**Covering Note to submissions dated 8<sup>th</sup> May 2026 re: Turnbridge Mills - Canals and Rivers Trust comments - Conditions 7, 23 & 34**

In summary, all the attached relate to the C & RT comments dated 24/4 and should all be sent to the Canals and Rivers Trust for re-consultation, including this covering note.

| Drwg. No. | 3310 74 | Revision | B | | | | | |

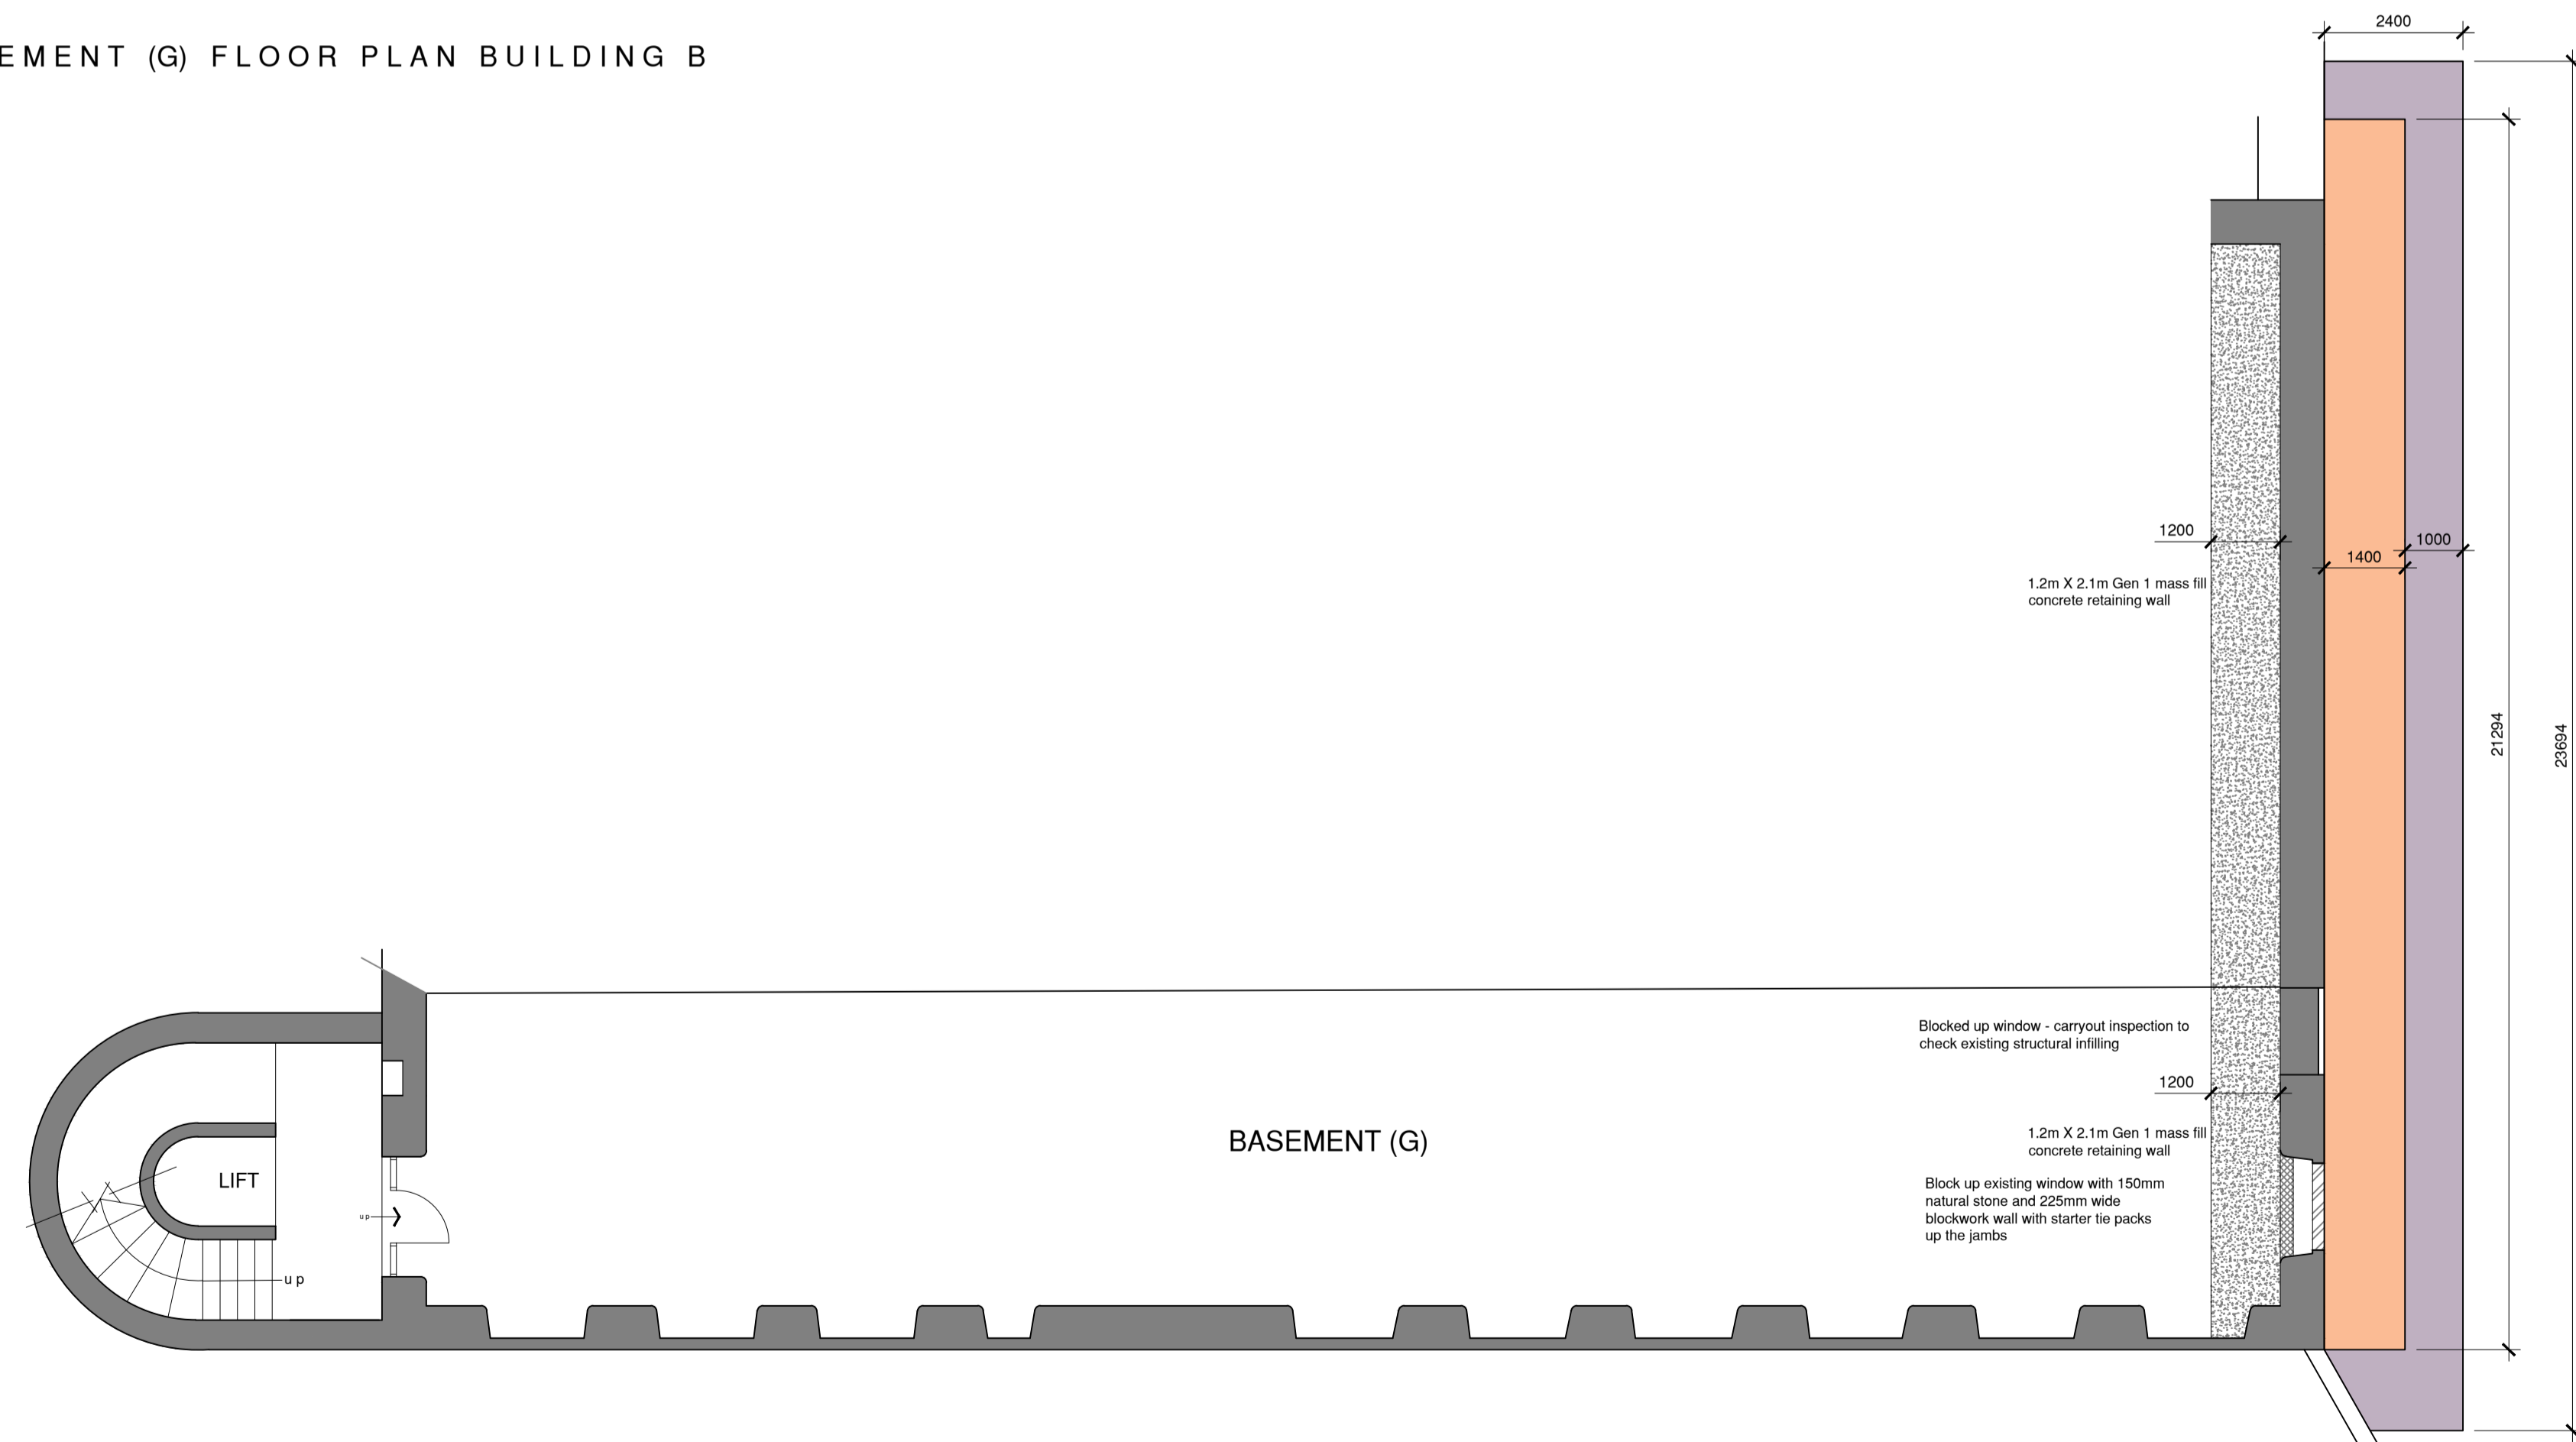
Condition 7 - T Jagers are already progressing an application with Alan Daines of the C & RT directly as you may be aware. Please see attached drawing 3310 74B showing area of scaffolding and floating protection pontoon as agreed with Alan. The plans also include a debris fan, and the boarding and netting will be extended down at each level as the building is demolished floor by floor.

PROPOSED CANAL SIDE EXTERNAL WORKS
SCALE 1:100

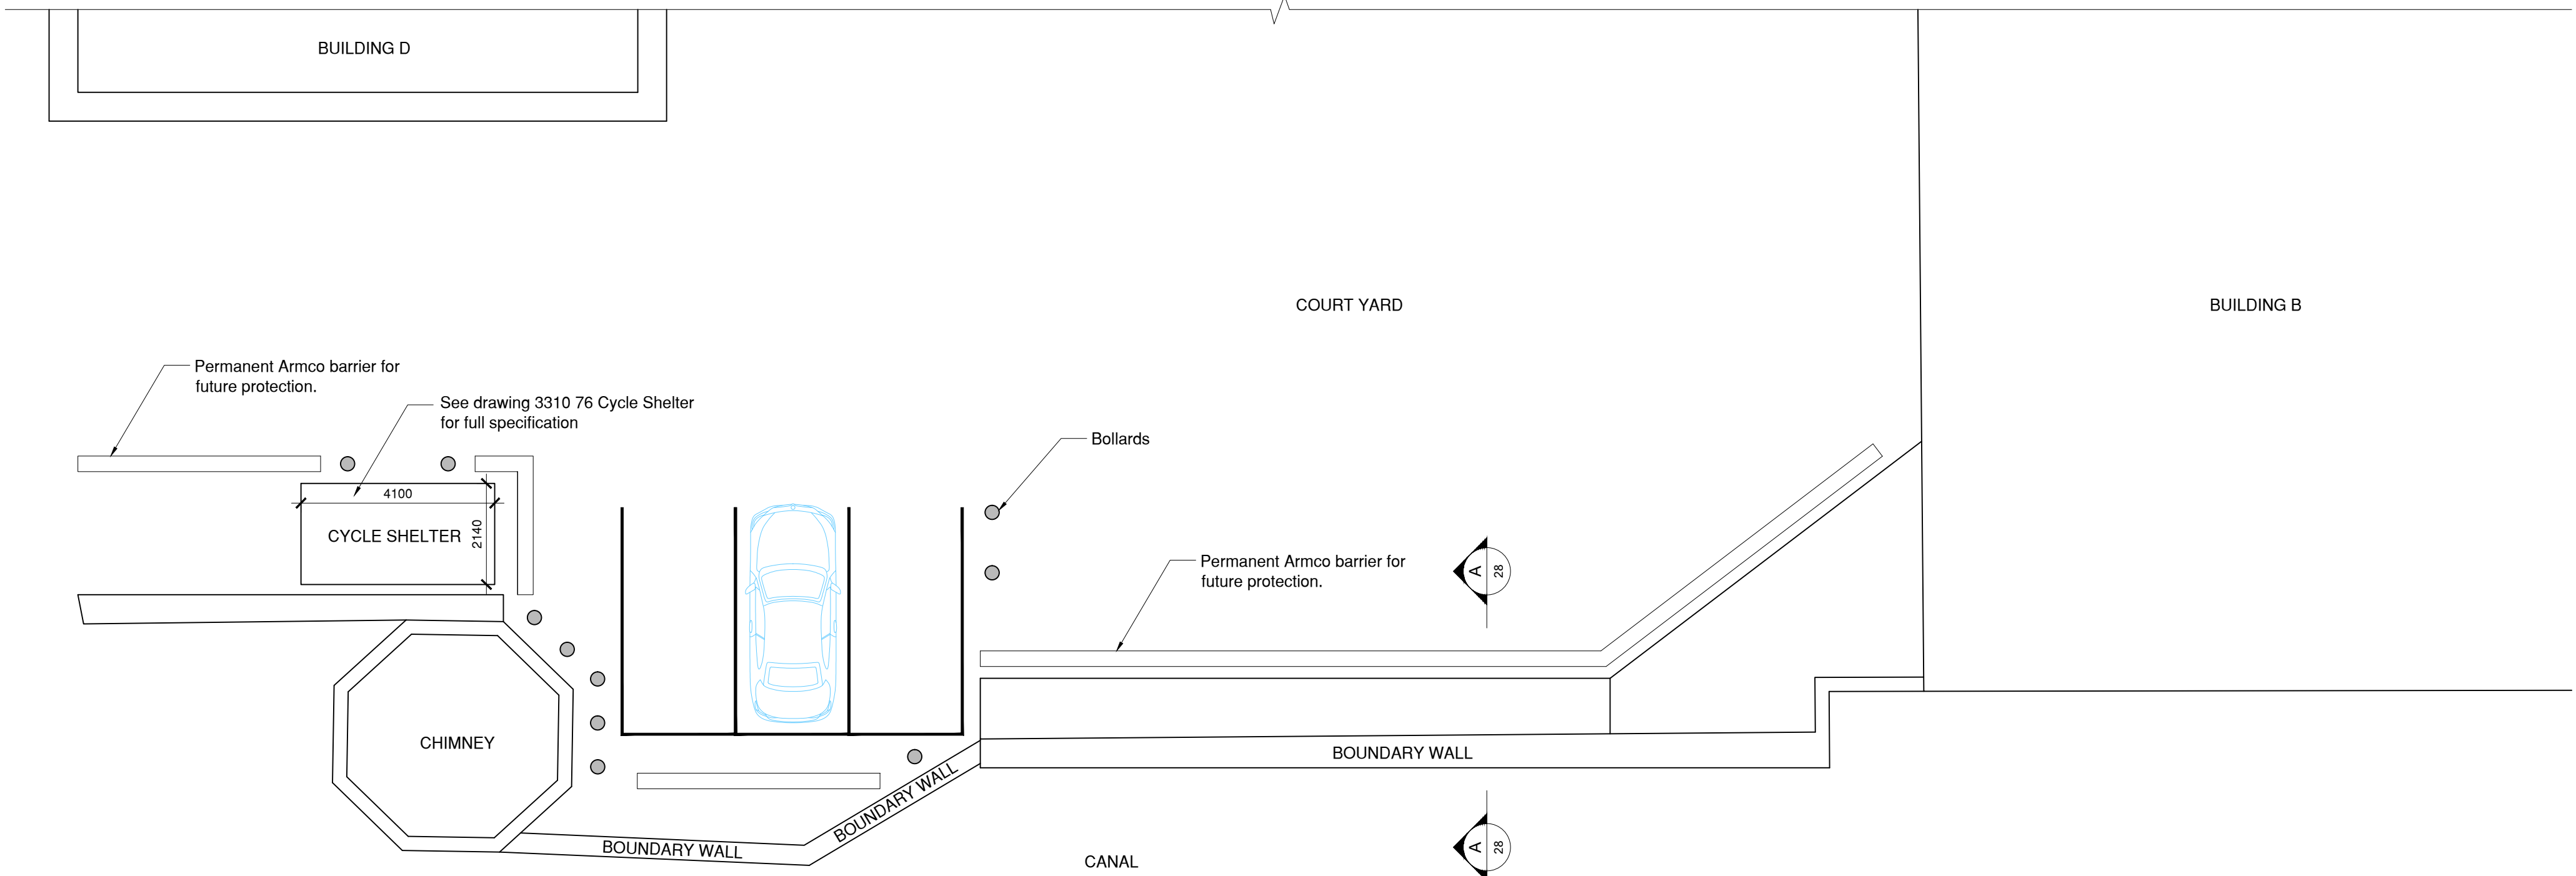
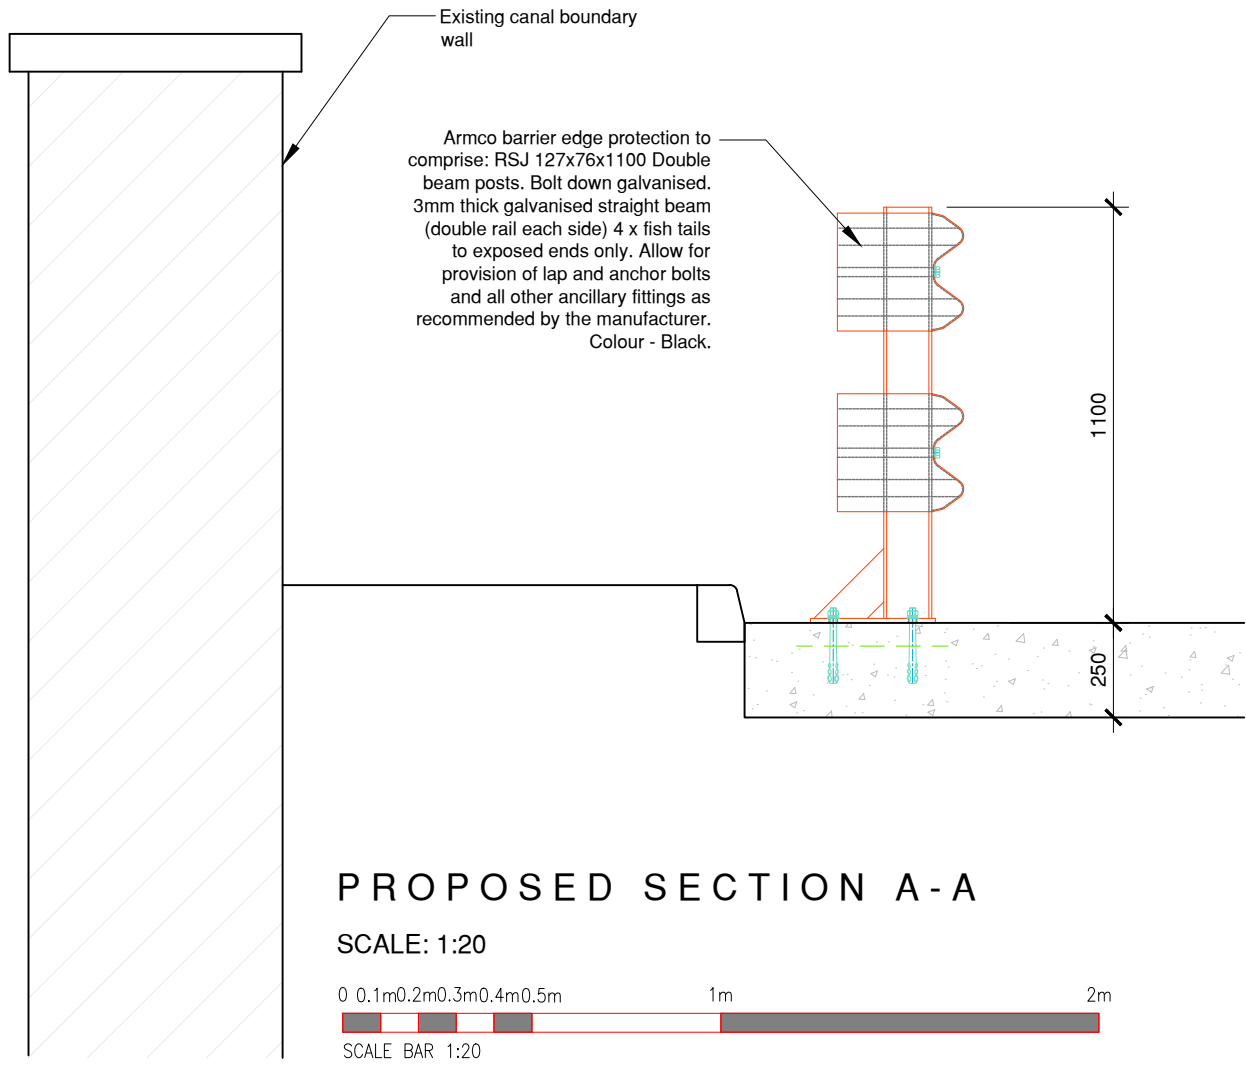
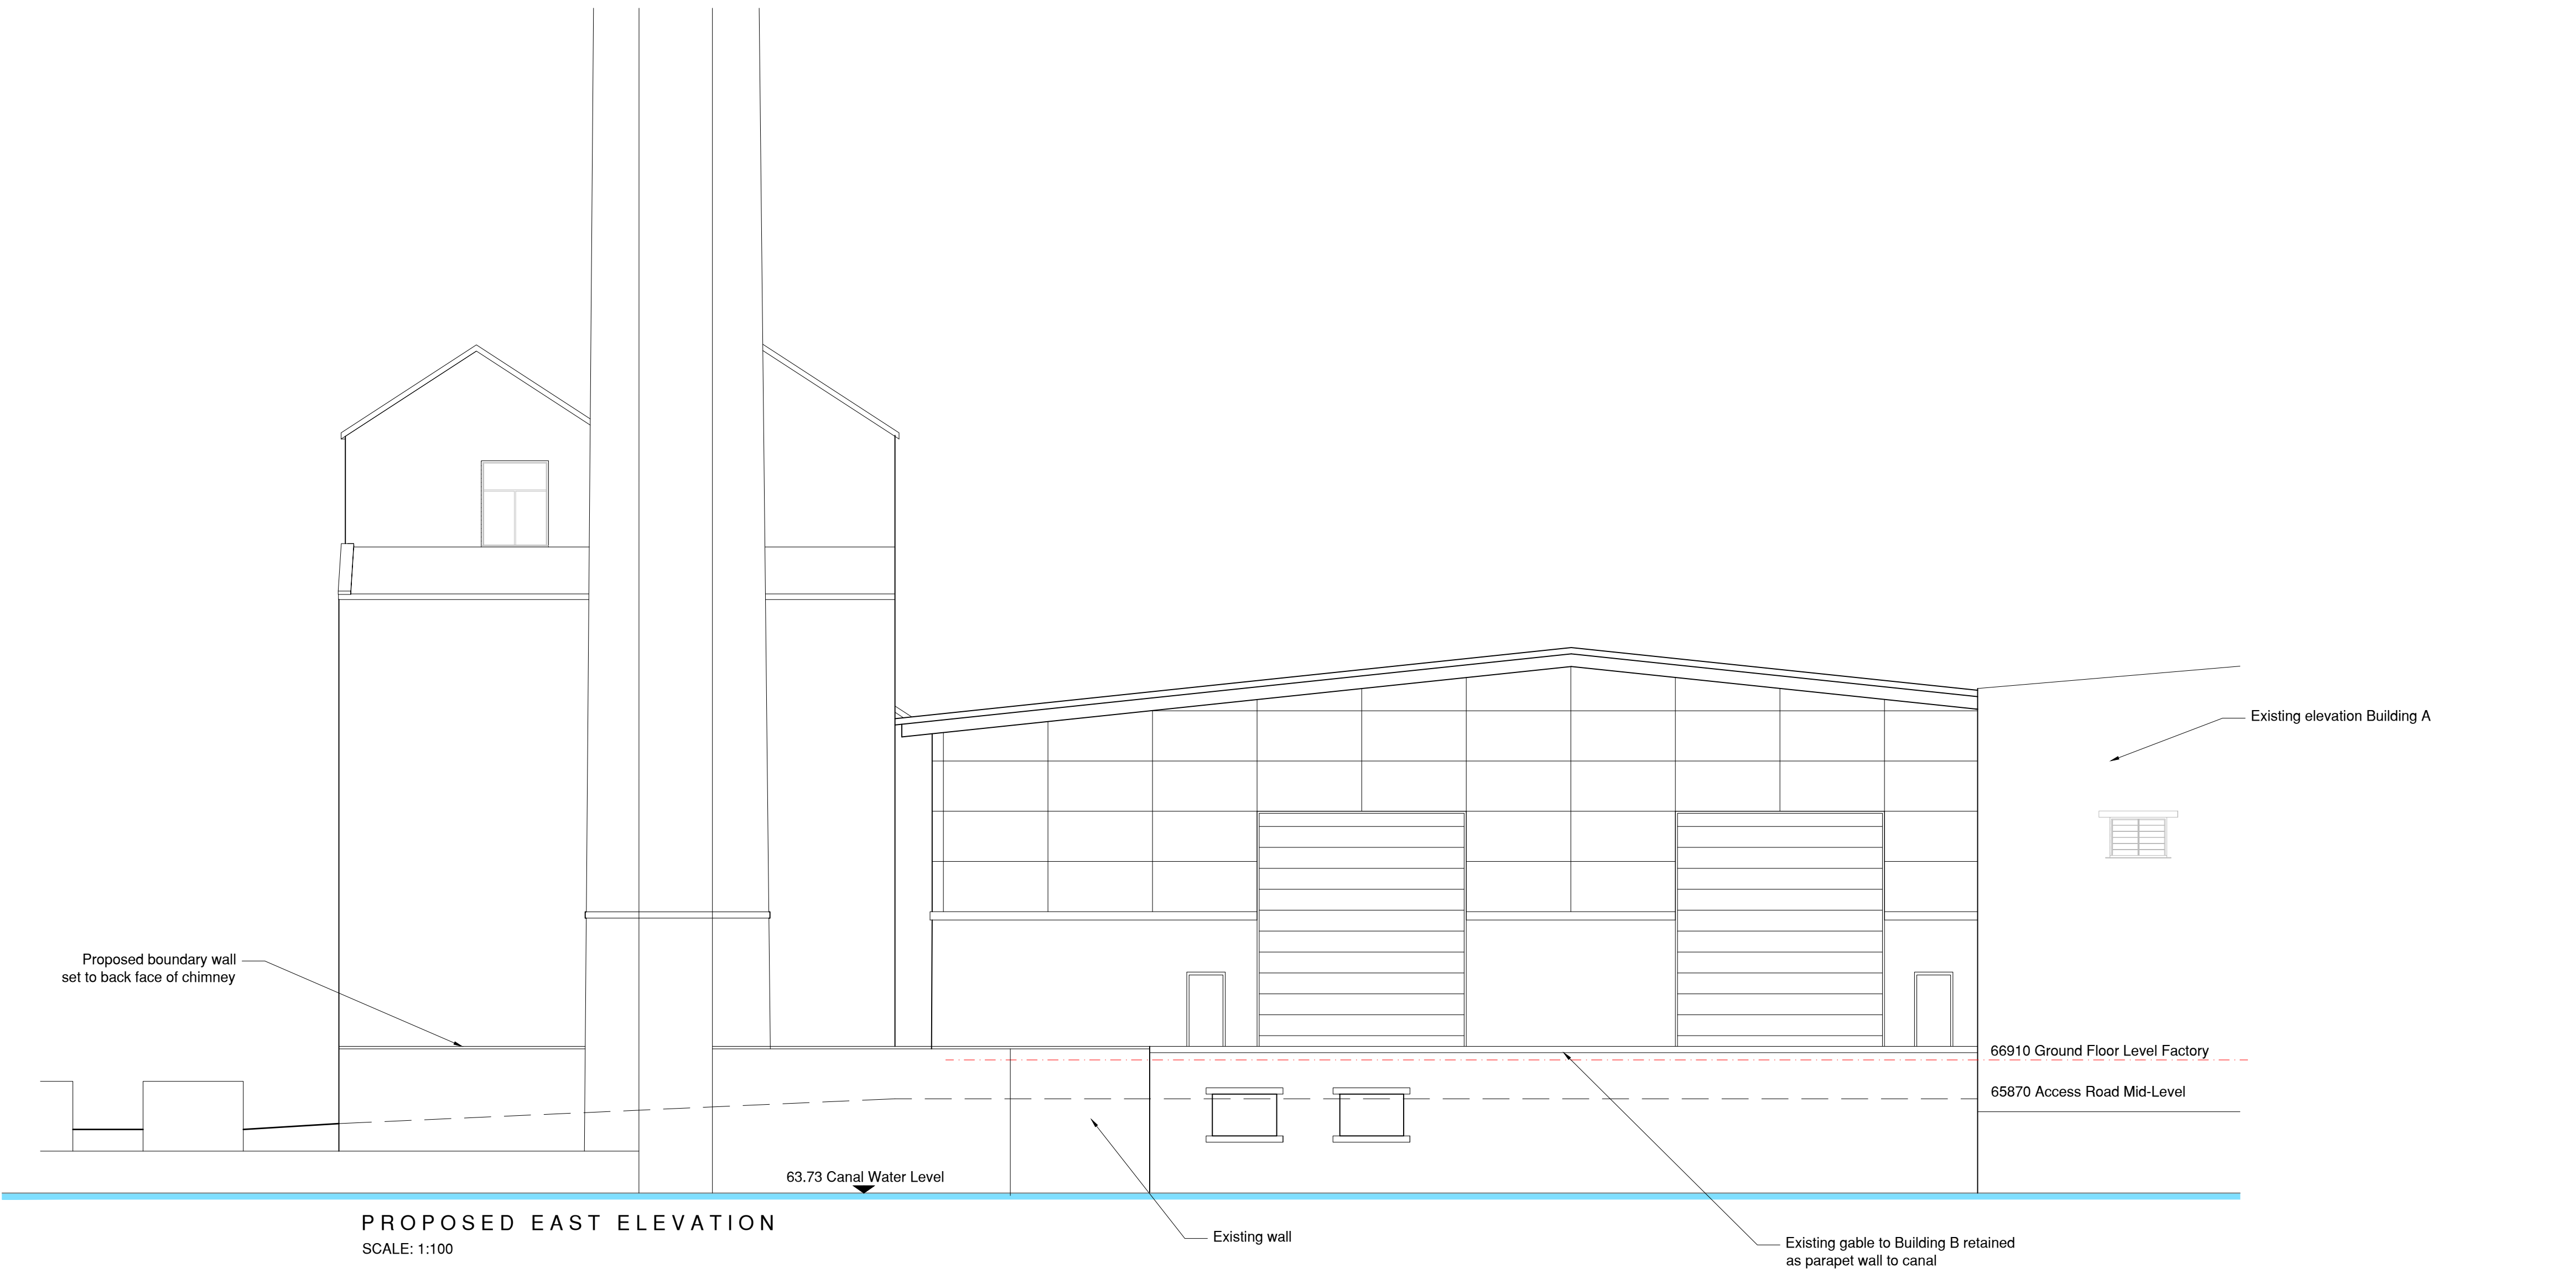
Condition 34 – Please refer to info submitted for Condition 7. The concrete work is below ground so no expansion details are required, the masonry wall will be visible above ground and this will be repointed and have a stone coping fitted. C & RT are aware of this and will hopefully confirm acceptance of the latest details.
